DARLINGTON PUBLIC SCHOOL
 SSD - 9914 ARCHITECTURAL DESIGN UPDATE

FOLLOWING RESPONSE TO SUBMISSIONS

GOLDEN GROVE STREET, DARLINGTON, SYDNEY
 Department of Education

Project Name		Darlington Public School	
Project Code		DTPS	
Document Name		SSD-9914 Architectural Design Update	
Revision	Date	Comment	Approved
REV 00	20.08.20	Design Change Report	EC

title
**Perspective Sections - Facade
Western Facade - FT01, 02**

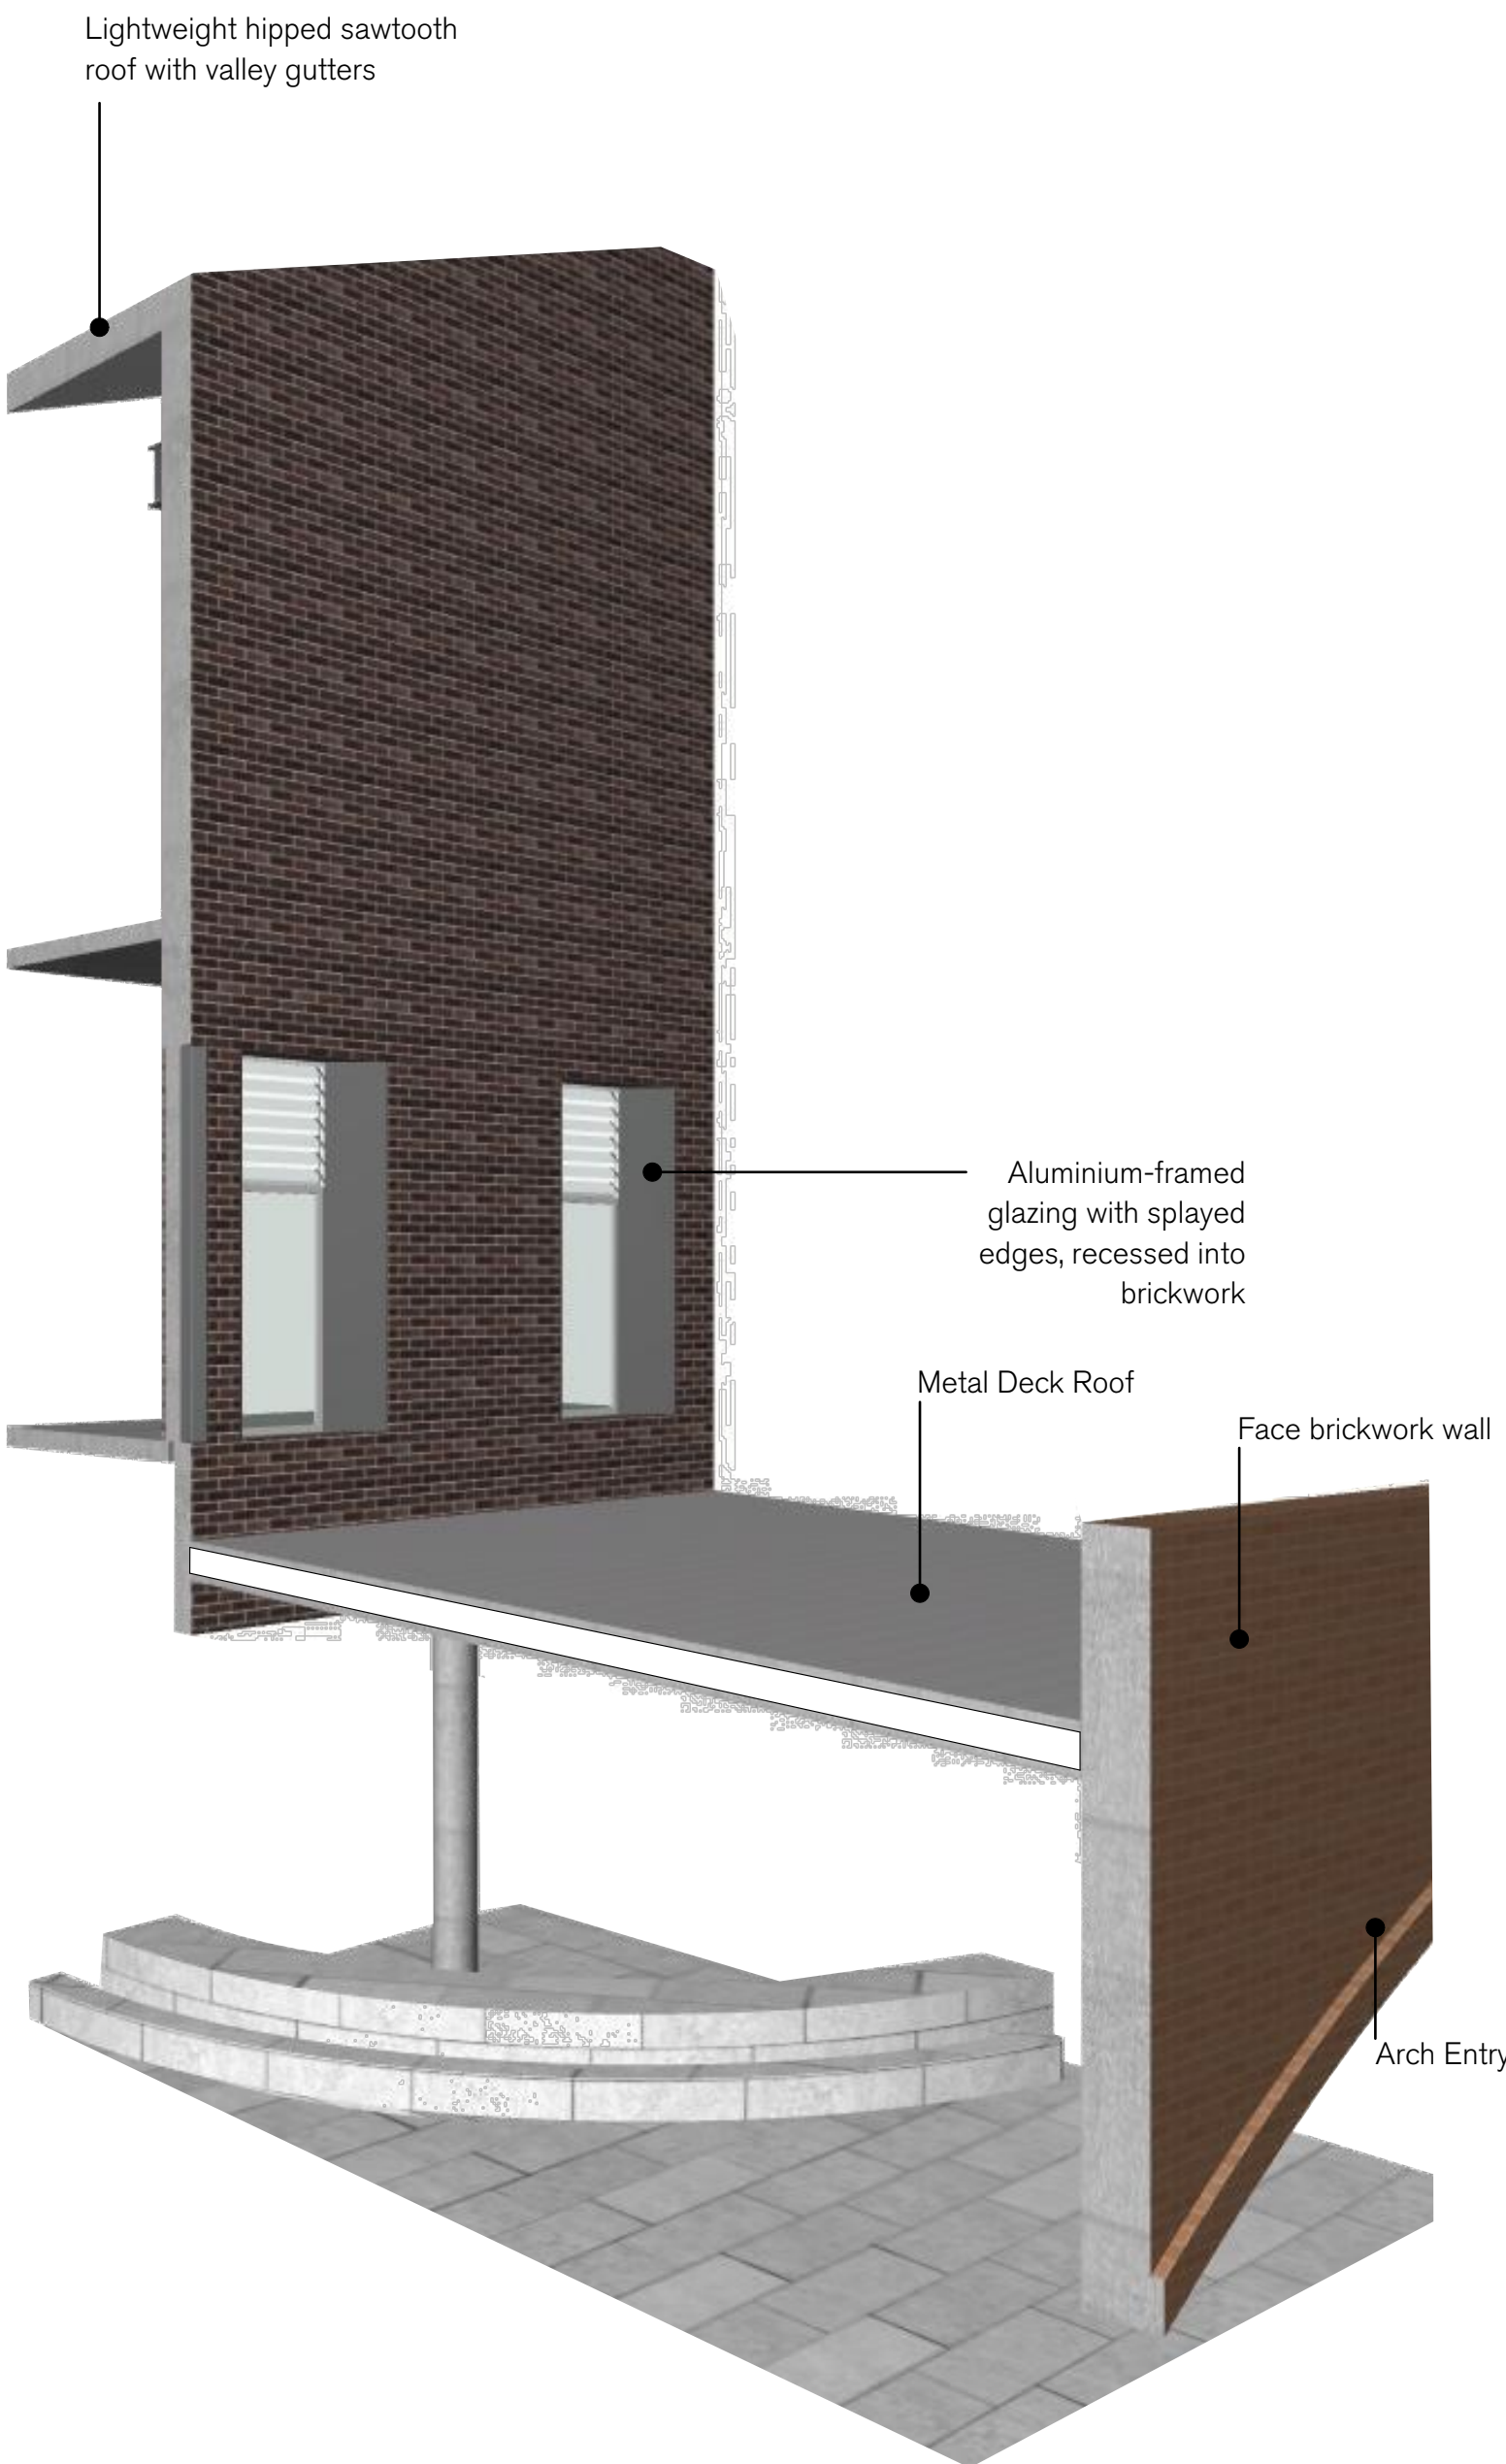
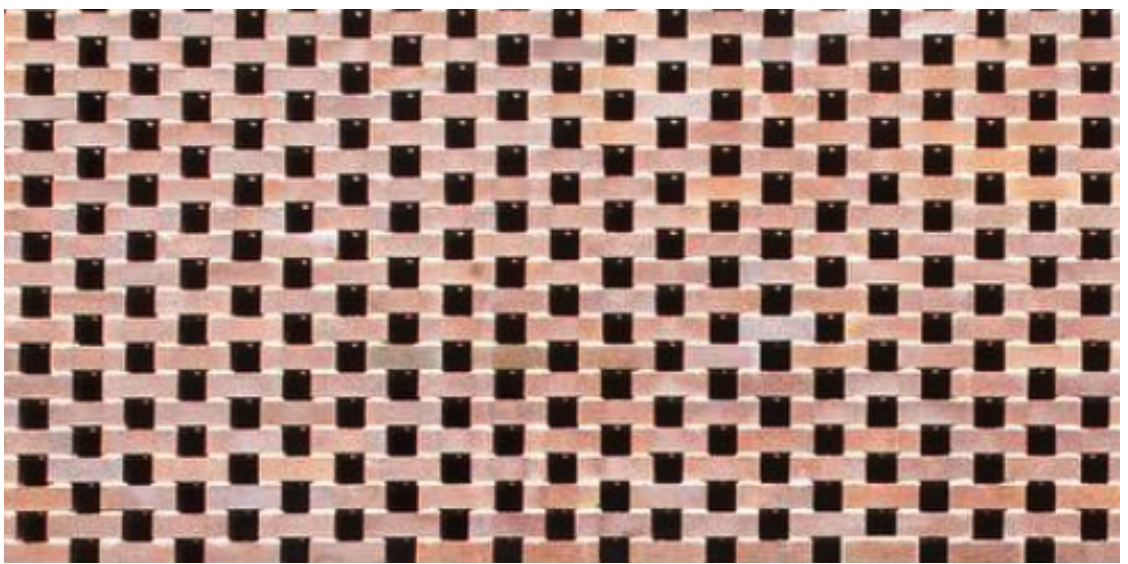
4.0 Change to Level 1 western facade

- The windows to the level 1 classrooms on the western facade (Golden Grove Street) have been changed from vertical slot windows to horizontal strip windows with vertical brick external blades, which provide solar shading from the western sun.
- This provides a larger expanse of light and views out from the classrooms, and a more integrated approach to the fenestration in this facade.
- In addition to this, a window has been added on the southern end of the western facade, due to the new staff room location above the hall.

title
**Perspective Sections - Facade
Western Facade - FT01, 07, 09, 10**

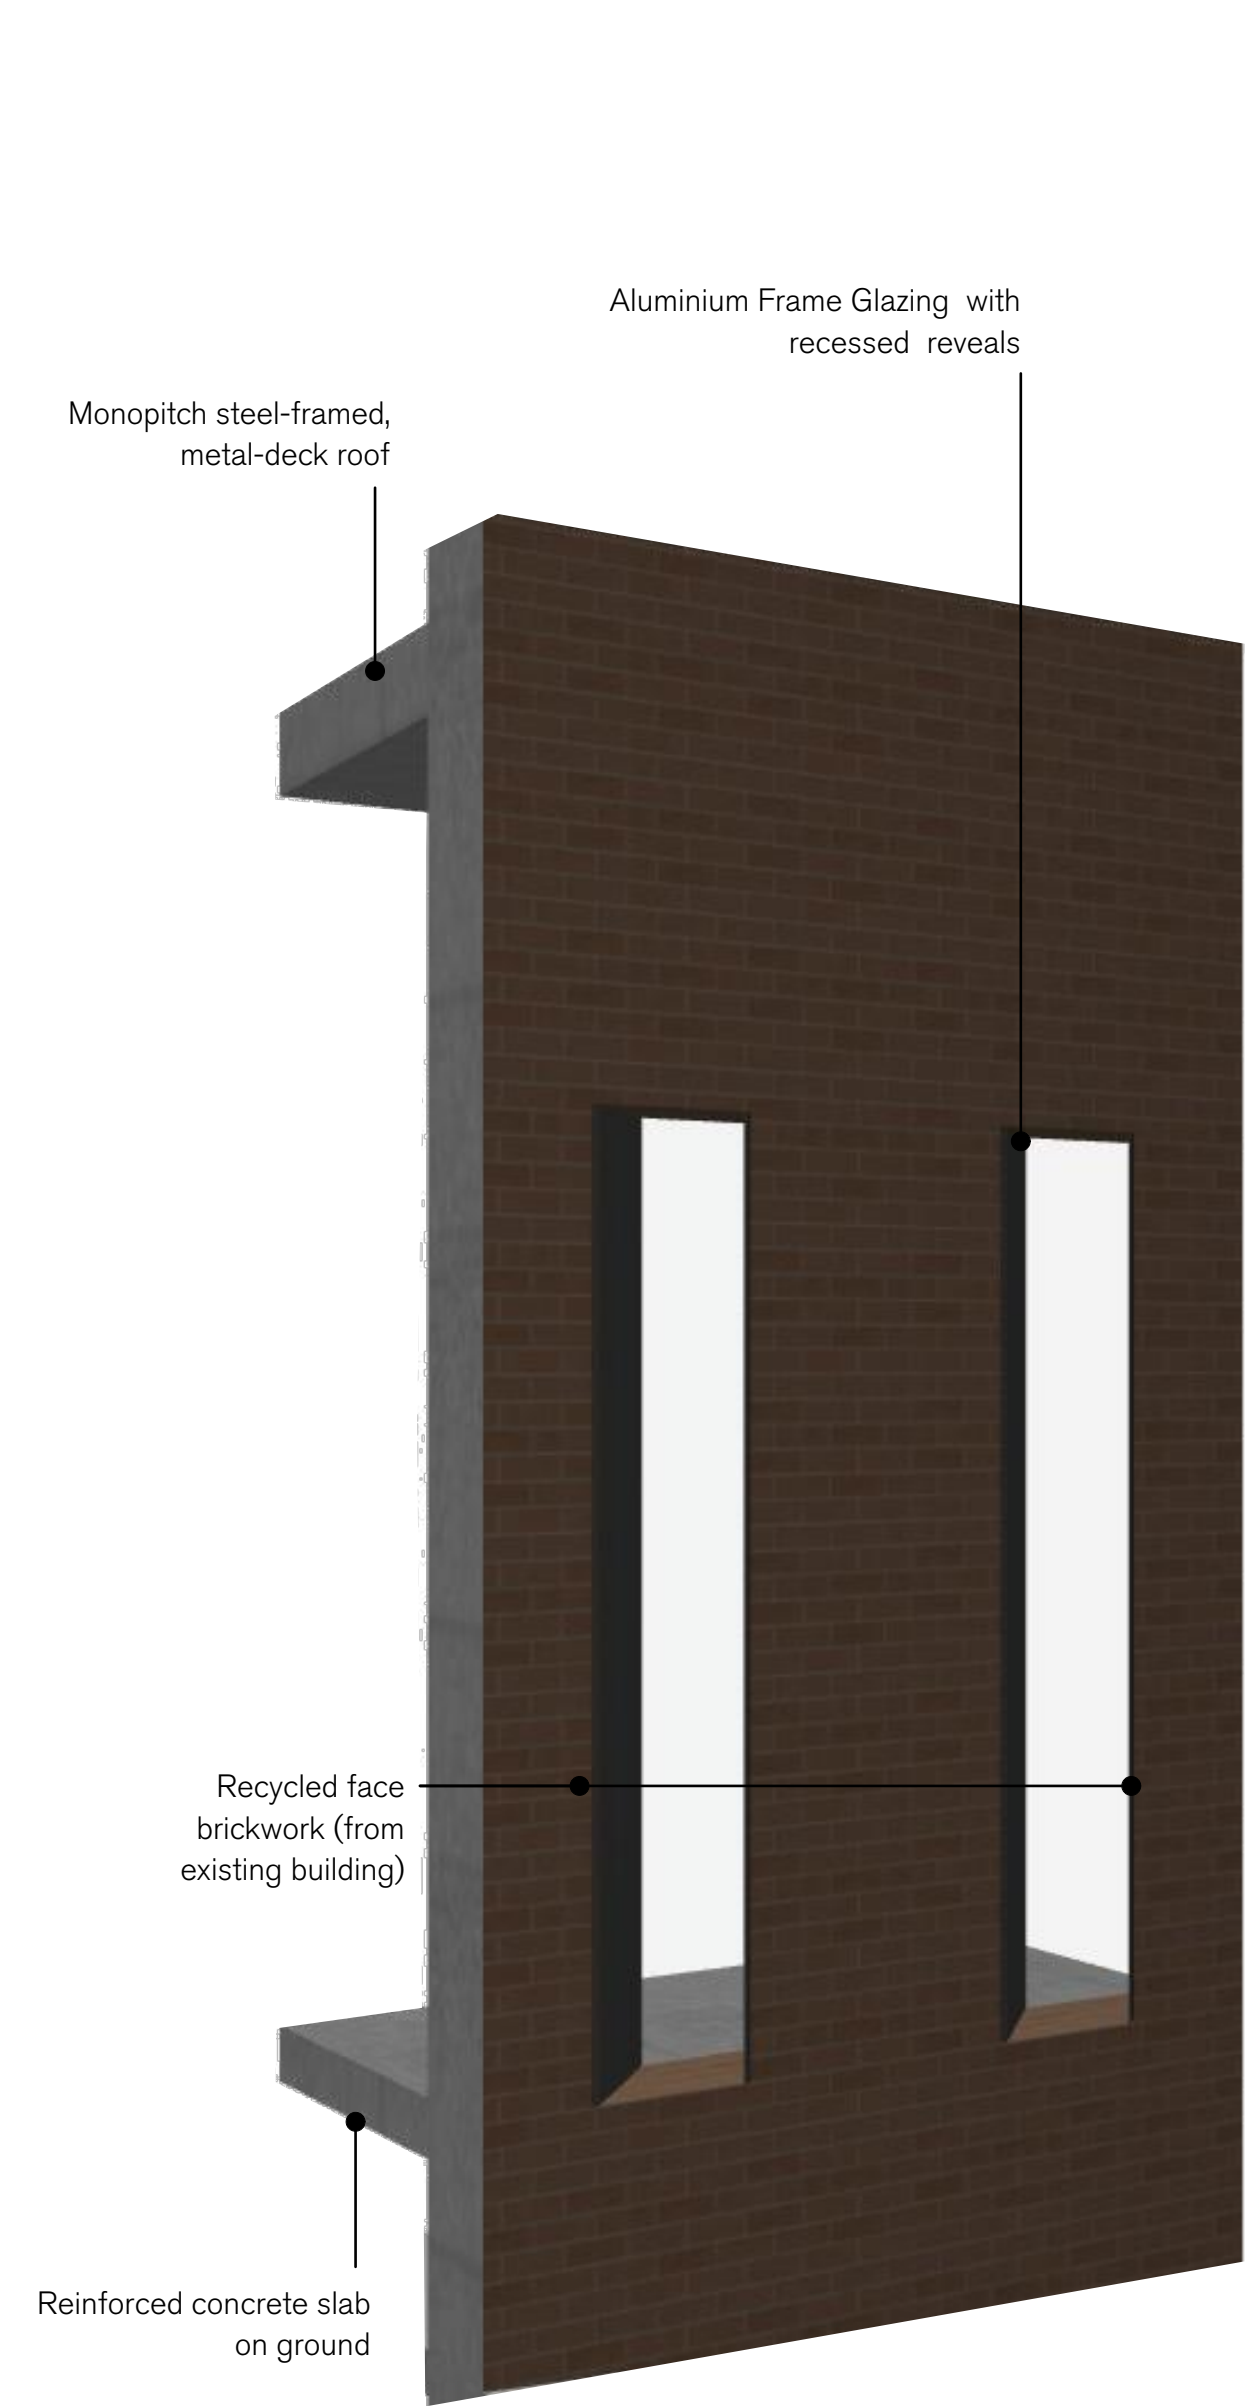
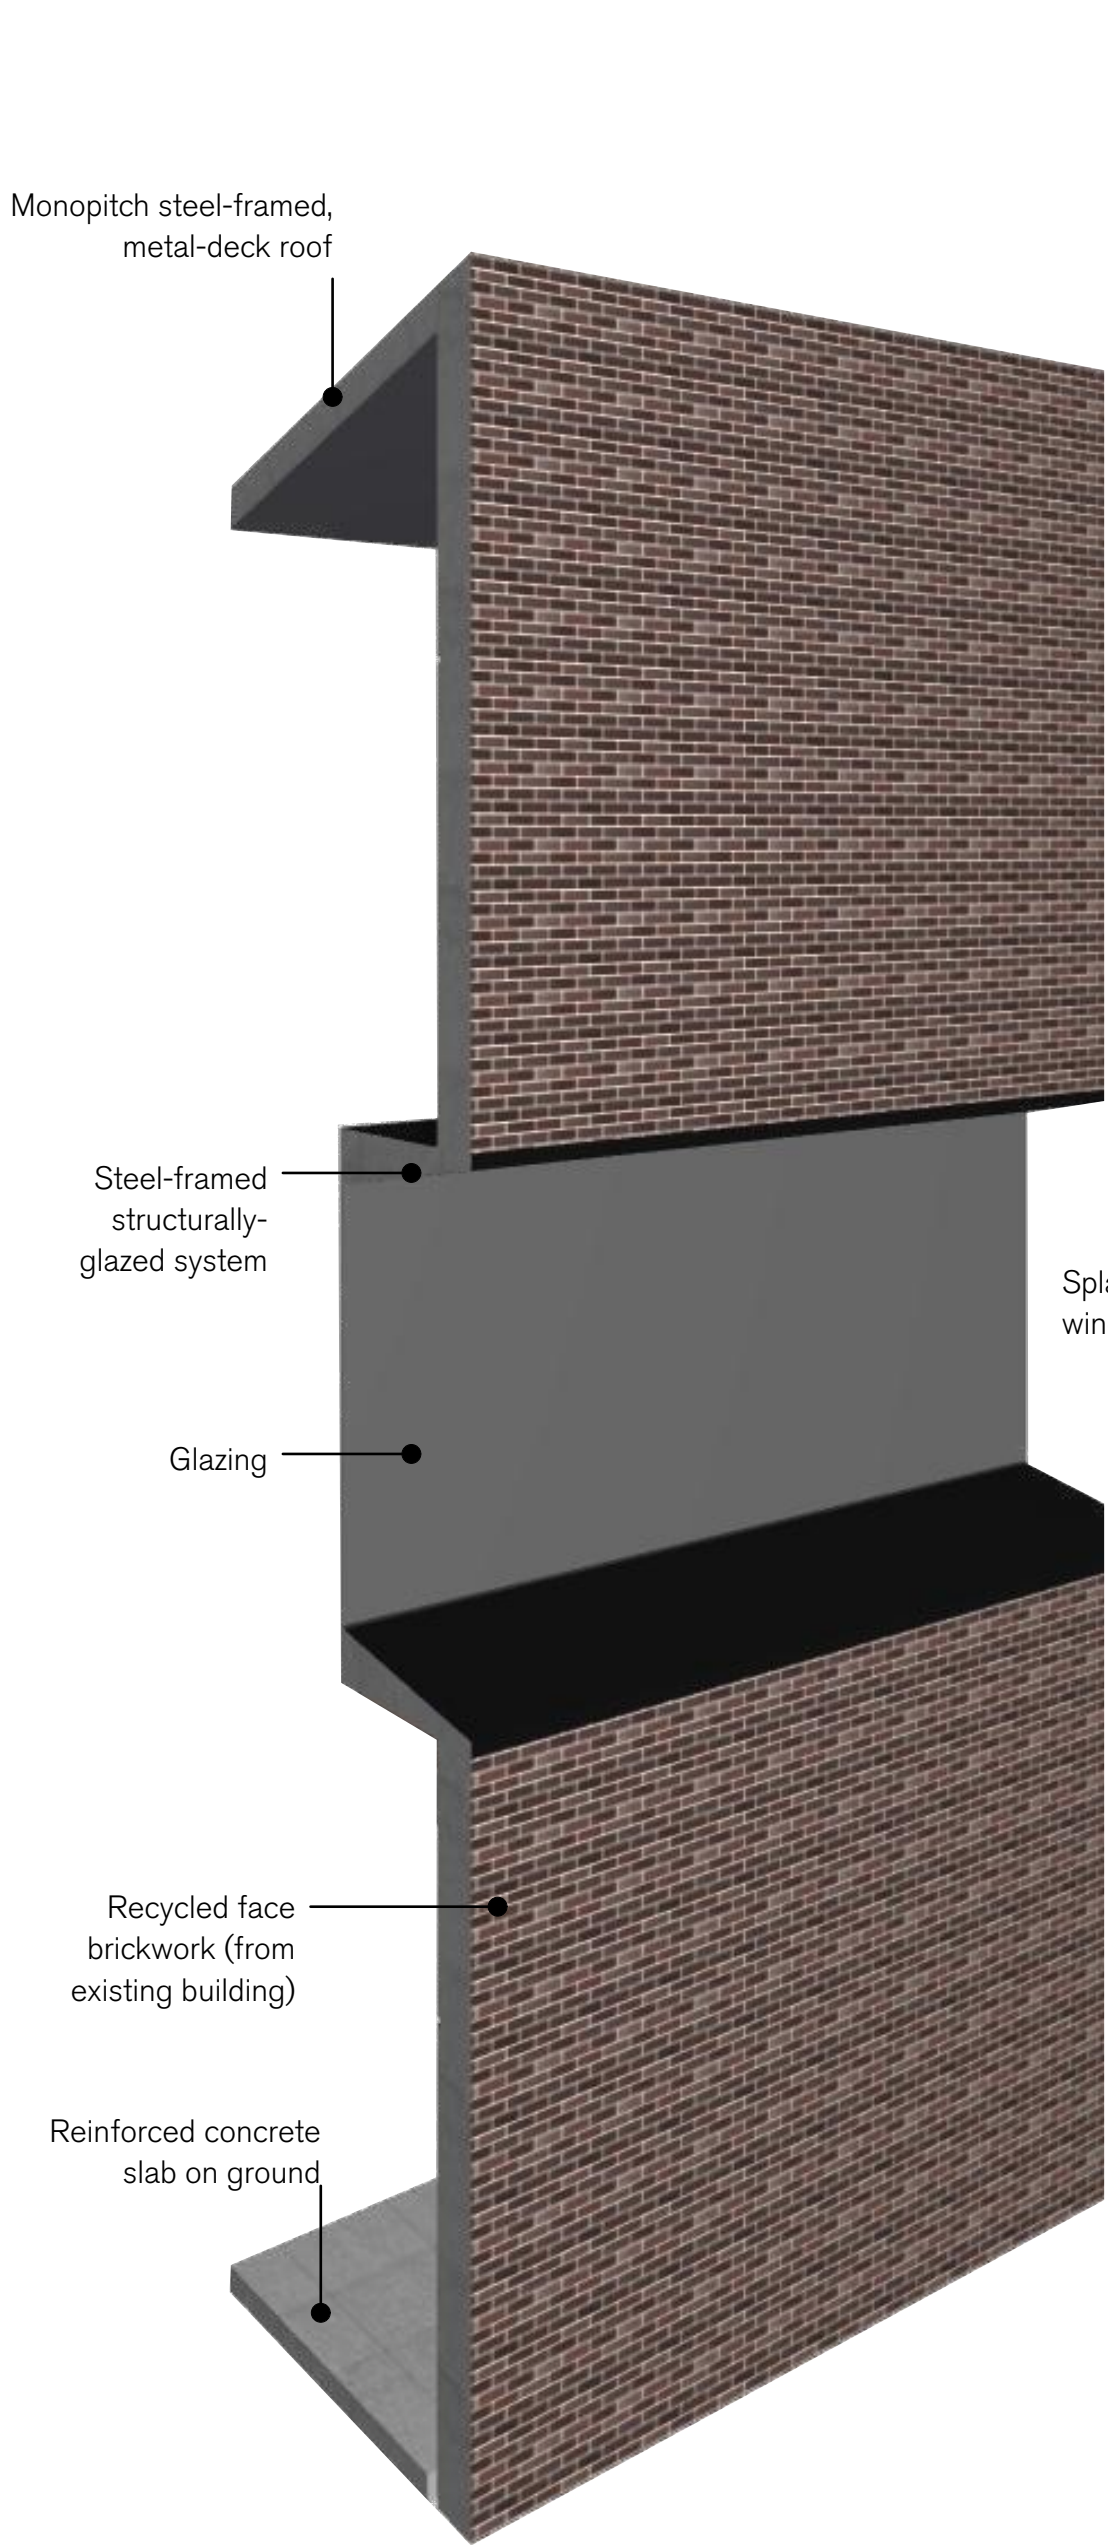
2.0 Articulation of the Southern Facade

- The glazing and brickwork to the southern facade of the hall building has been articulated to provide a finer grain response to the streetscape.
- The previous single large window into the south facade of the communal hall has been divided into 5 smaller windows. These are set into a recessed brick facade with large splayed sills and clearly defined brick blades between the glazing elements.
- This creates a more interesting street frontage, responding to the local context and a more structurally efficient result.
